DRB CASE ACTION LOG - BLUE SHEET

Project #: 1009945 Application #: 14DRB-70124  
Project Name: Lands Of ~~John~~ Josh Romer  
Agent: The Survey Office Phone #:

**CITY OF ALBUQUERQUE  
PLANNING DEPARTMENT  
May 7, 2014  
DRB Comments**

**RE: Tracts 127 & 130 MRGCD Map #35**

**PLAT OF
LOTS A & B
LANDS OF JOSH ROMERO
PROJECTED SECTION 12, T. 10 N., R. 2 E., N.M.P.M.
ALBUQUERQUE GRANT
CITY OF ALBUQUERQUE
BERNALILLO COUNTY, NEW MEXICO
APRIL 2014
SHEET 2 OF 2**

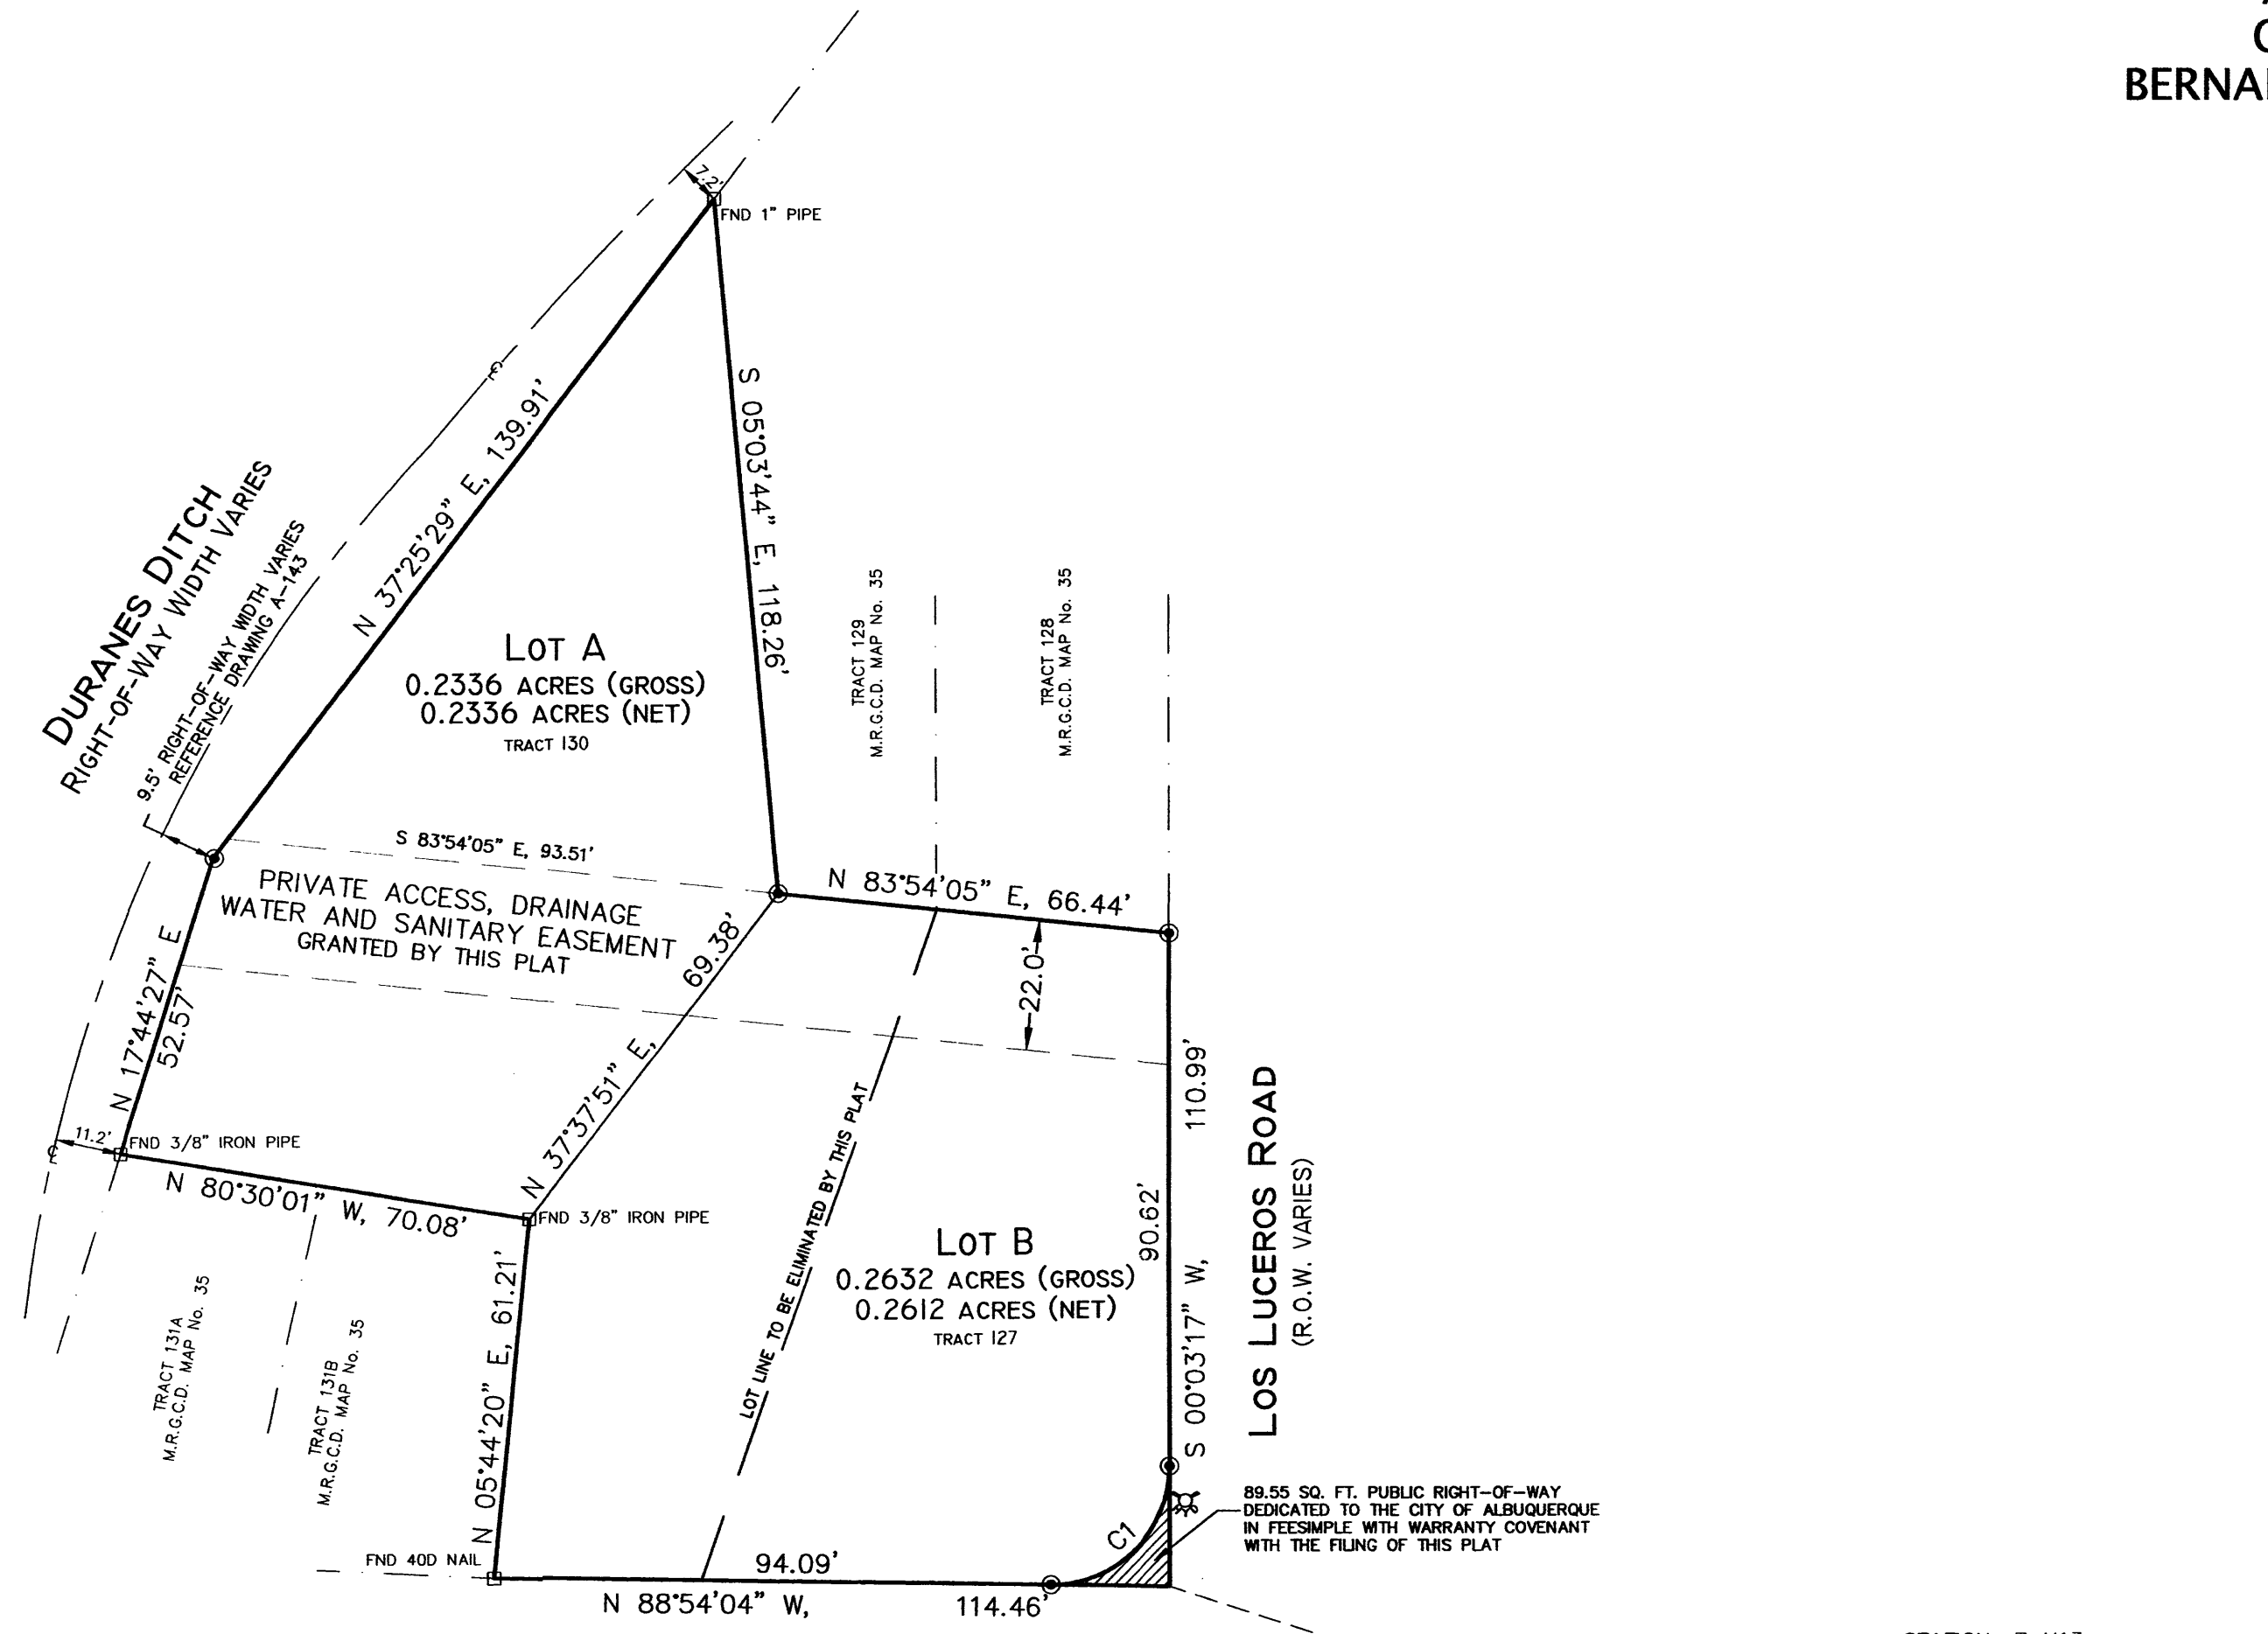
PLANNING (Last to sign): dx6 utility signatures  
owner's acknowledgment of new E'ment

Per Sketch Plat comments, it needs to be demonstrated that the proposed rear lot is buildable with a 22 foot easement running through the middle –Zoning Enforcement needs to verify required setbacks and how large a building footprint is possible on a site sketch. Maintenance and beneficiaries of easement(s) need to be called out on plat.
